Marge Schmuckal - Re: 34 Howard St.

Marge Schmuckal - Re: 34 Howard Street - 2014-01970 - 014-E-019

From: Marge Schmuckal [mailto:MES@portlandmaine.gov]
Sent: Tuesday, September 02, 2014 3:08 PM
To: tomlandry@benchmarkmaine.com
Subject: 34 Howard Street - 2014-01970 - 014-E-019

EXISTING ELEVATIONS
A3

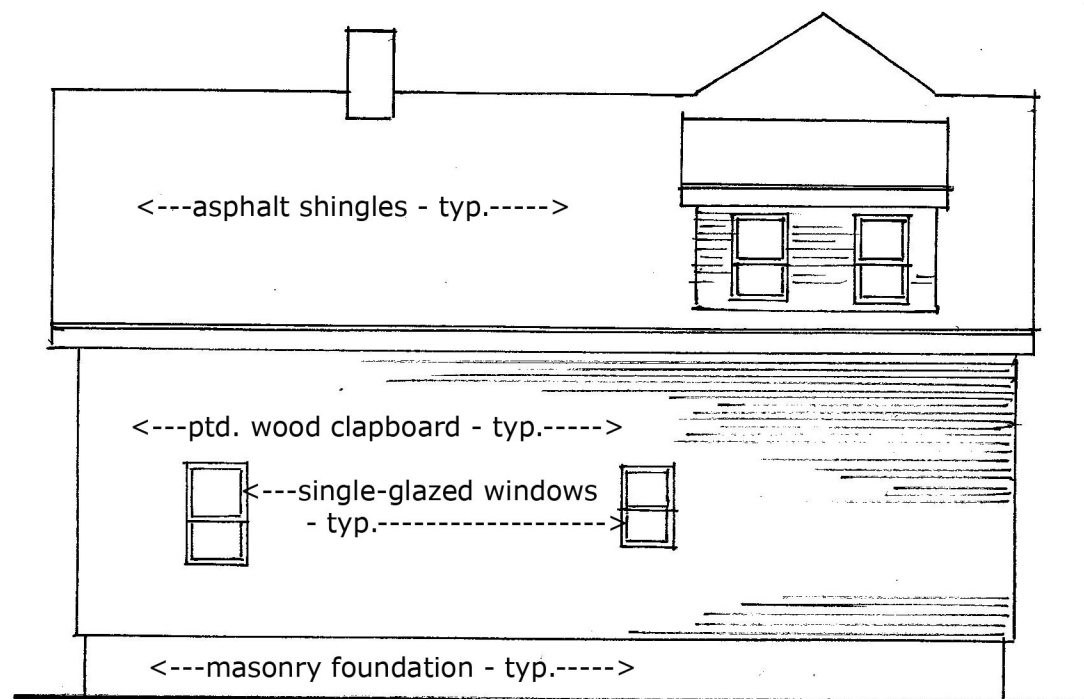
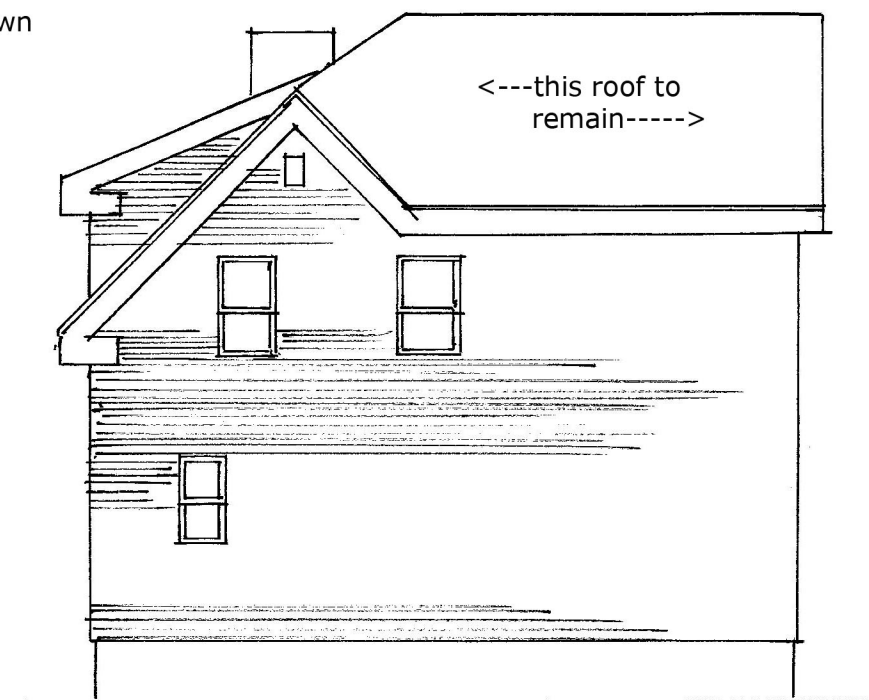
2. The existing roof plan on Drawing A2 notes that a large section of the roof is to be re-built (largely due to very insufficient existing framing). Existing elevations on Drawing A3 also note the areas of roof to be re-built.

PROPOSED
ELEVATIONS
A5

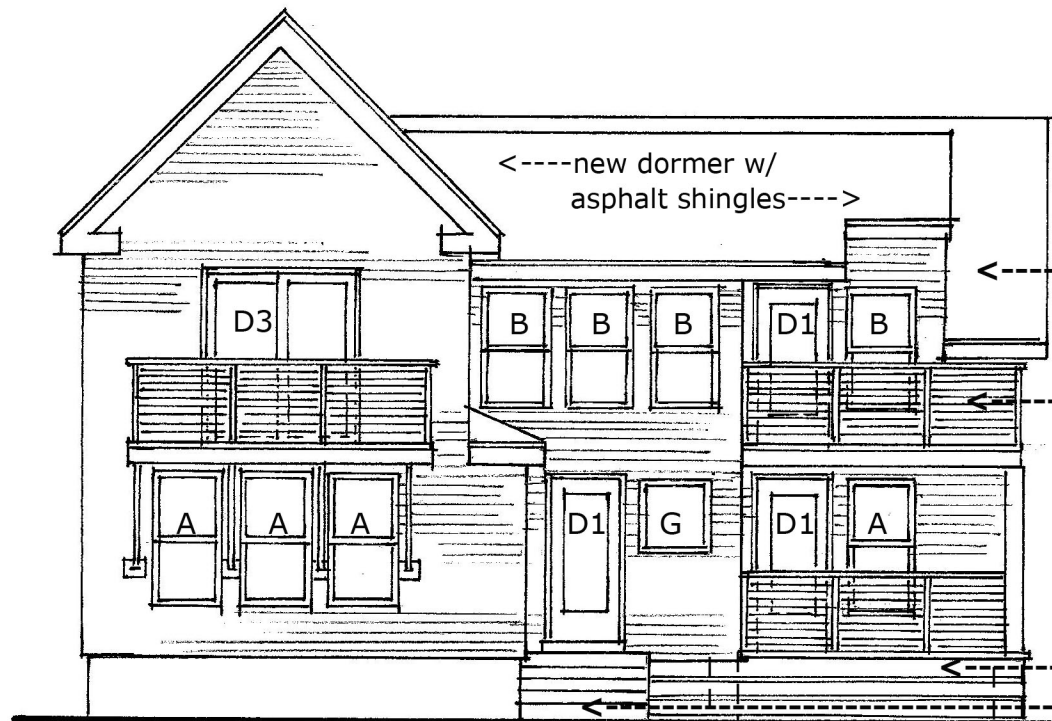
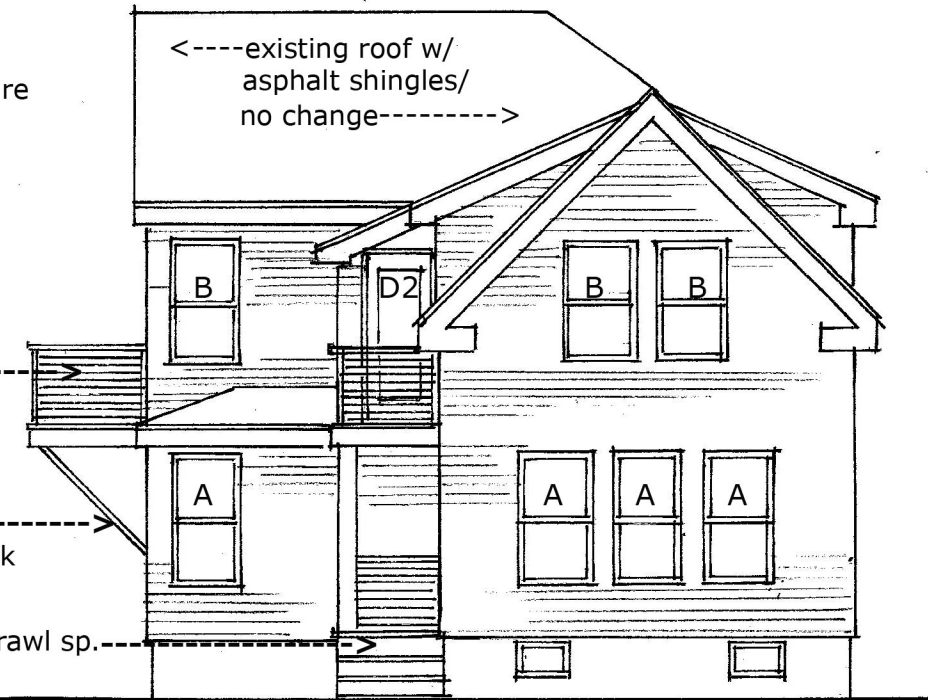
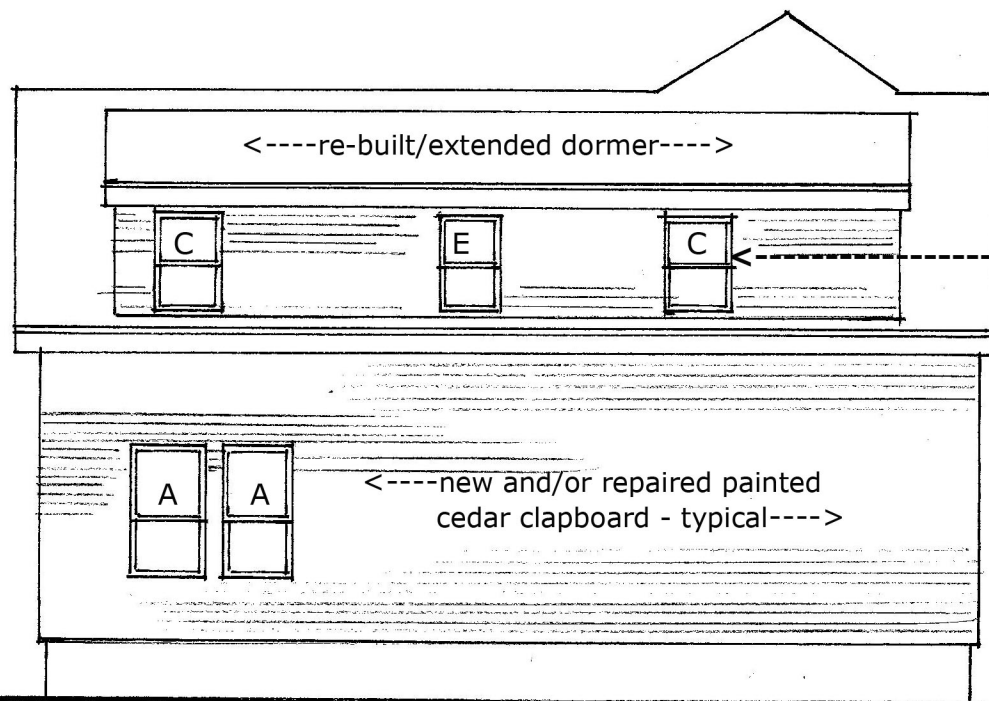
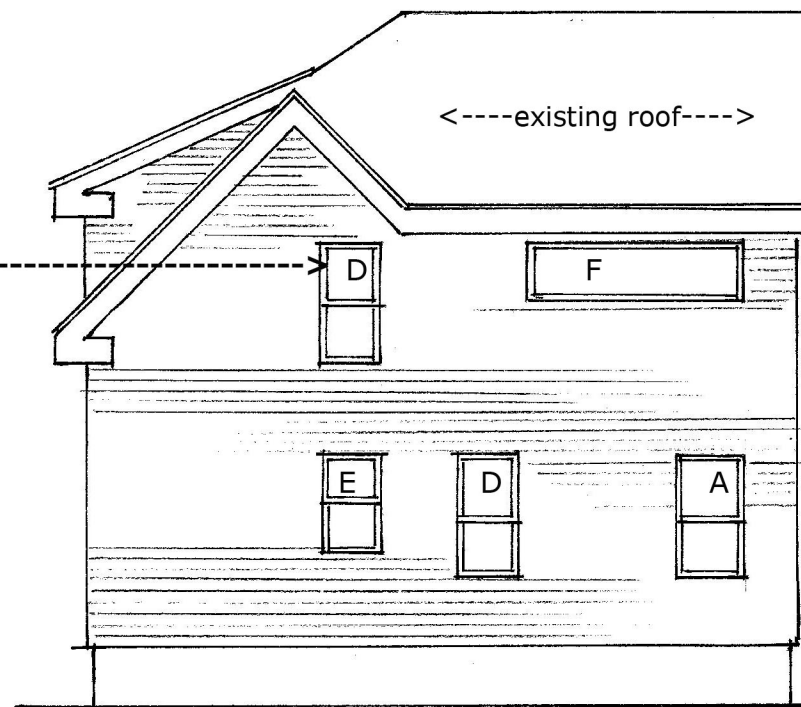
3. The Proposed Roof Plan on Drawing A3 and Proposed Elevations on Drawing A4 indicate which is existing dormer area to be re-created, and where expanded or new dormers are located.

5. As a point of clarification, the proposed deck off of the second floor Master Bedroom is technically not cantilevered, as diagonal steel supports attached to the wall below are included - rather than posts that land on grade.

BUILDING SECTIONS  
A6

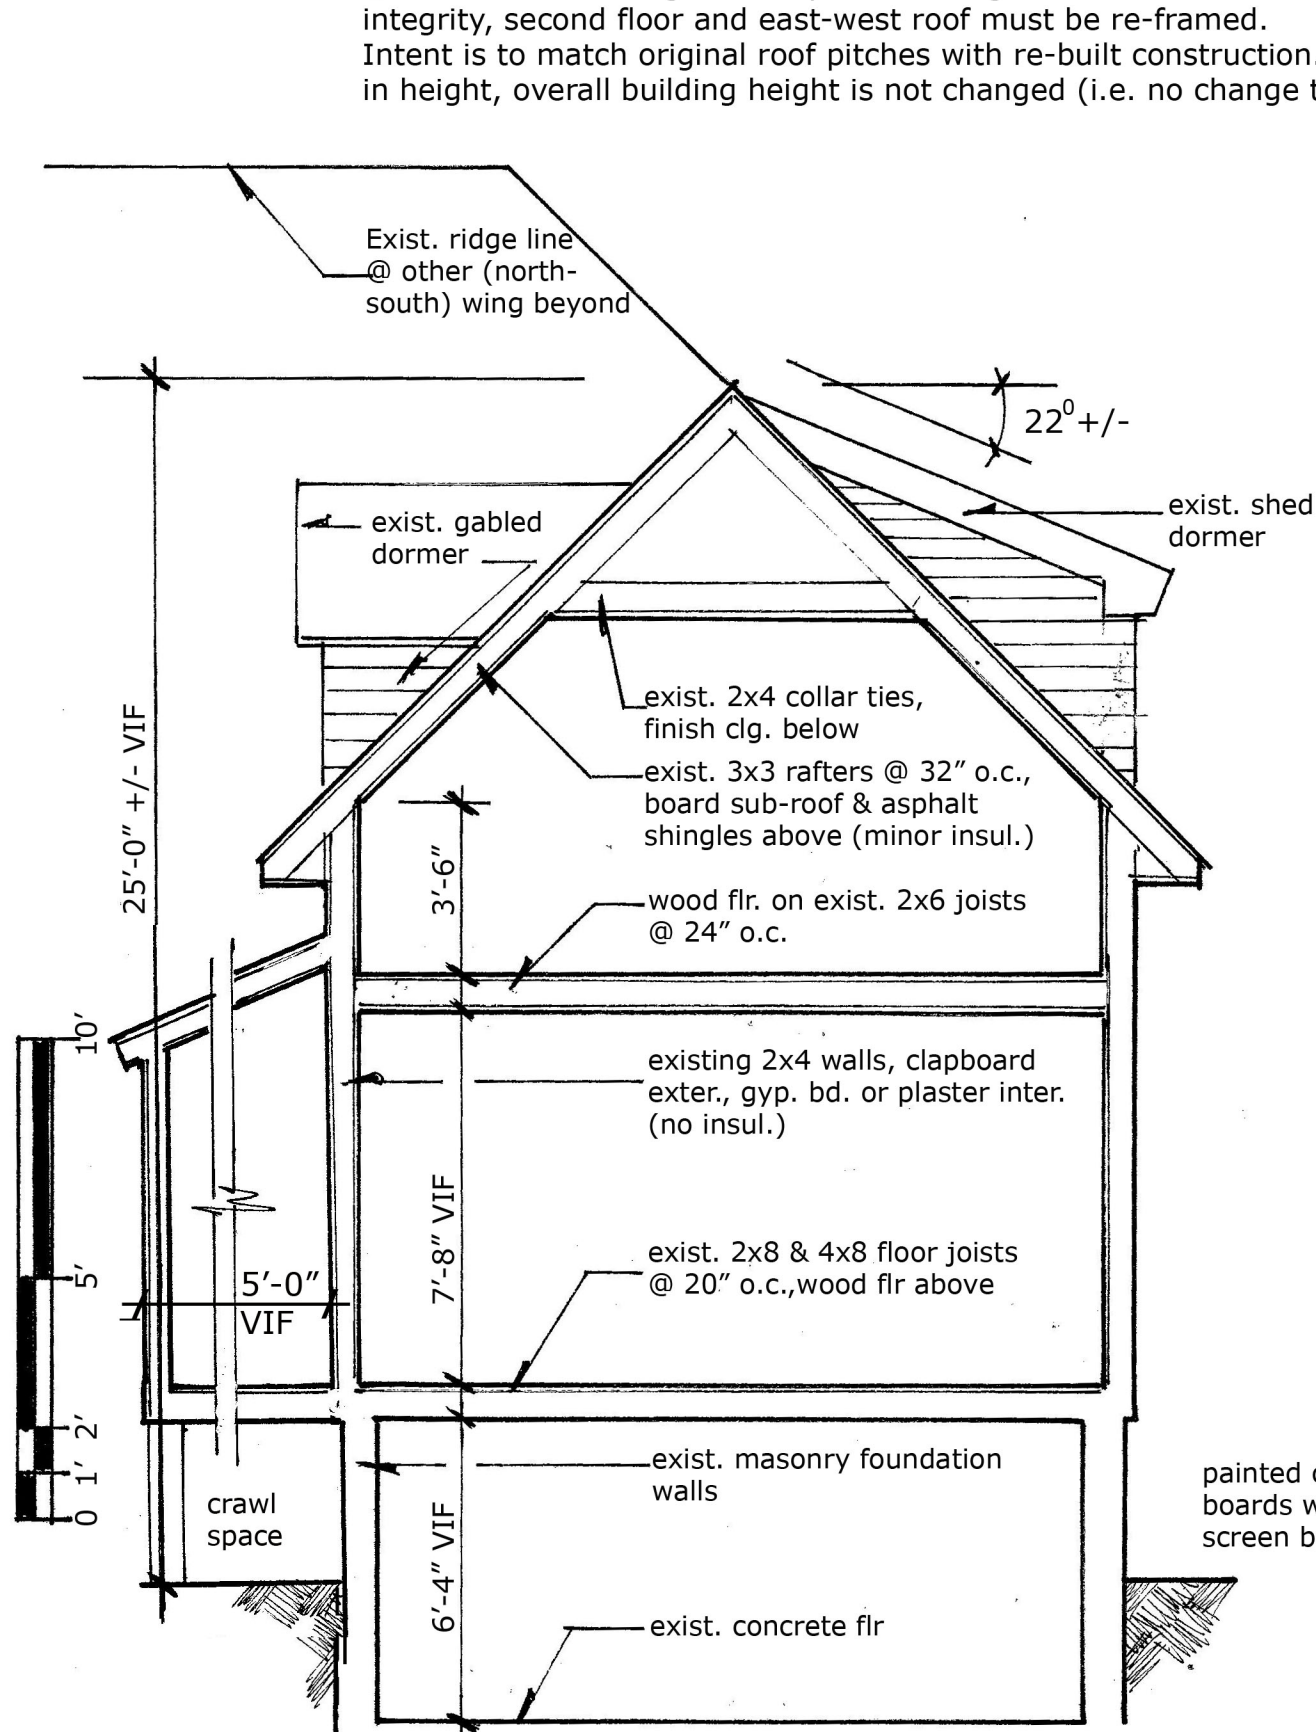
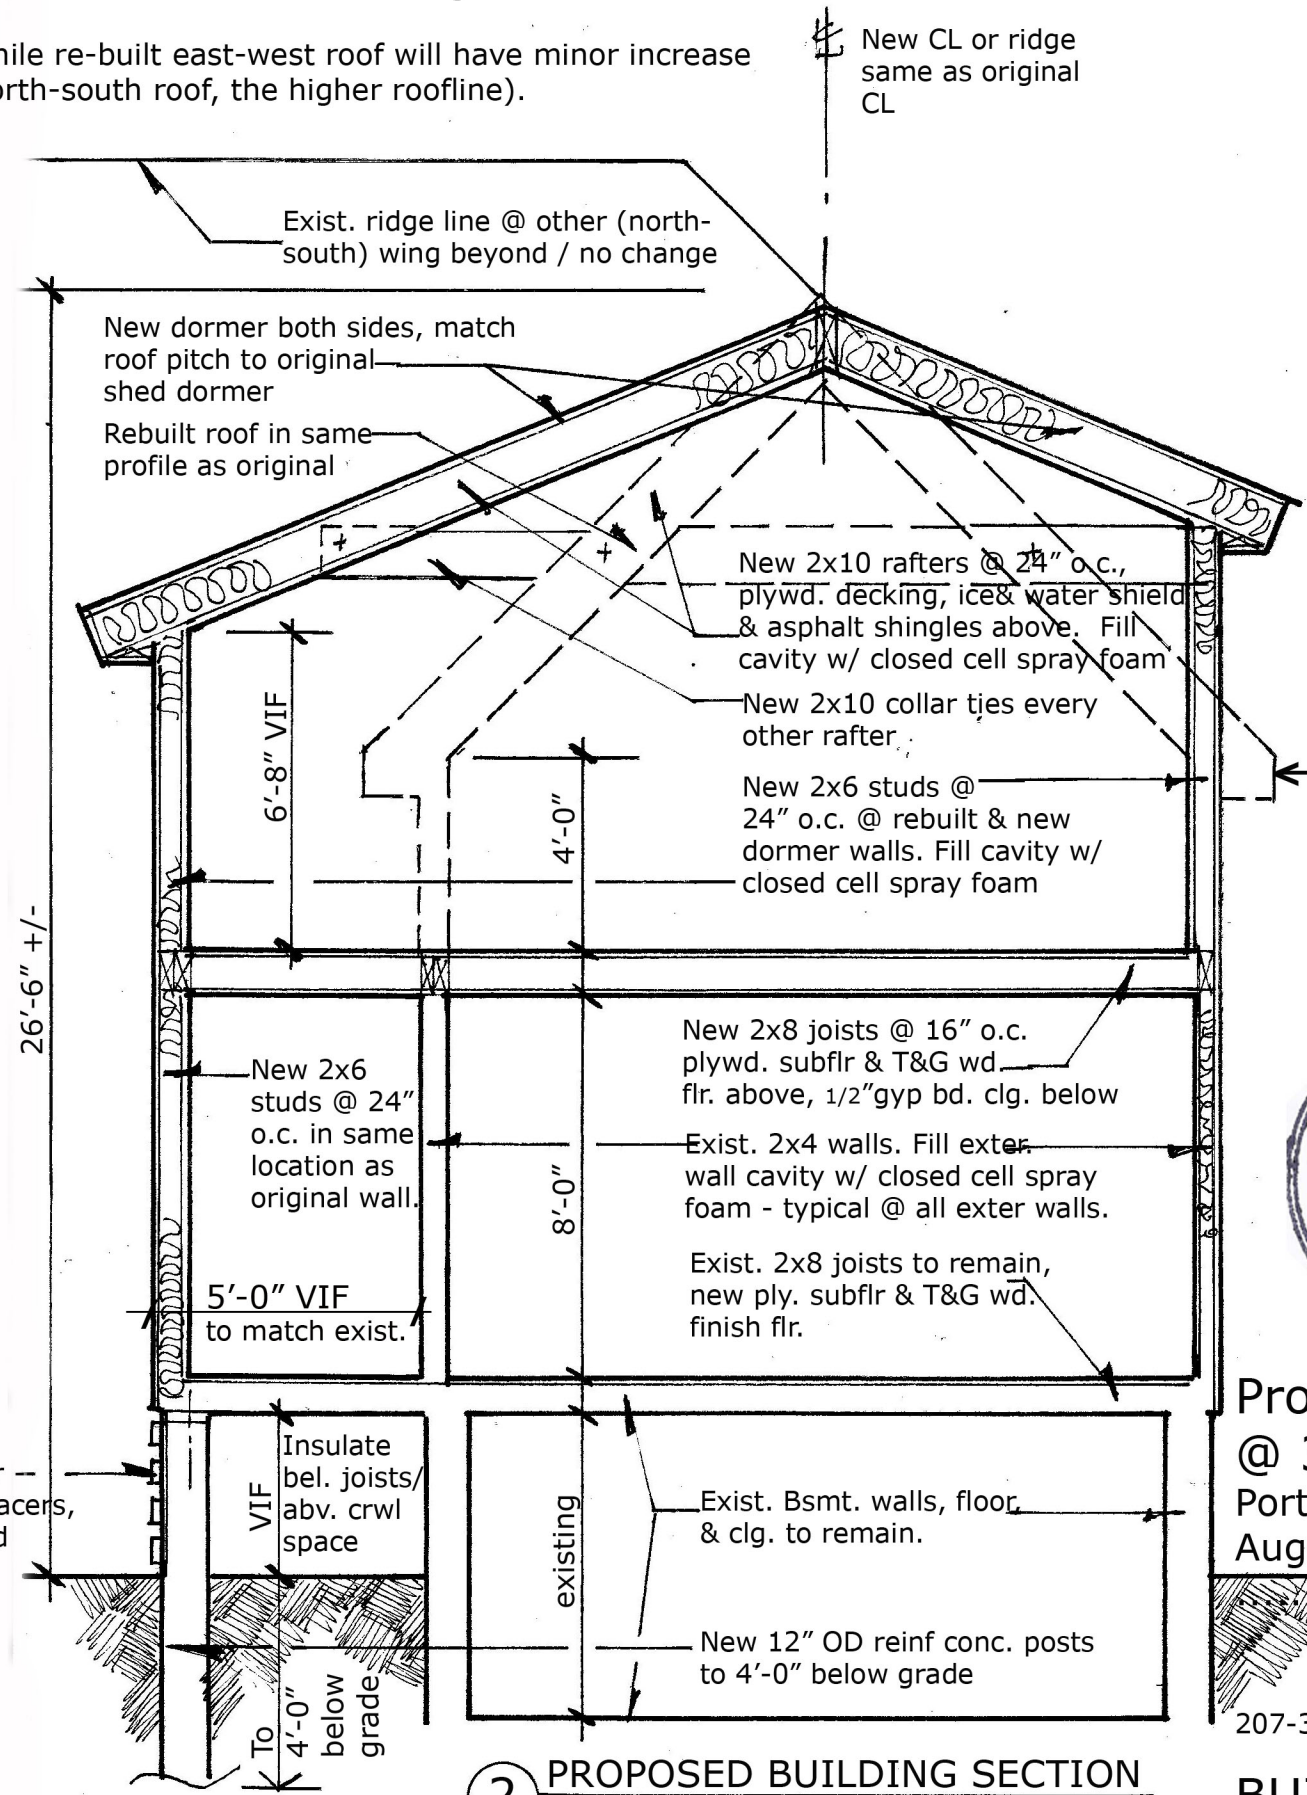
4. Most importantly, the **overall height of the building is not changed**, as the highest roof-line is existing and is to remain. **The net additional square footage is 78 SF**, created by the new dormer on the south side of the east-west roof, and includes footage on both the first and second floors (though the majority of added footage is at the second floor). This number is well under the additional footage allowable for a non-conforming building when the existing roof-line limits head height. **The building footprint, relative to it's lot lines, is also not changed**. There is no change to curb-cut or location of perimeter fencing.
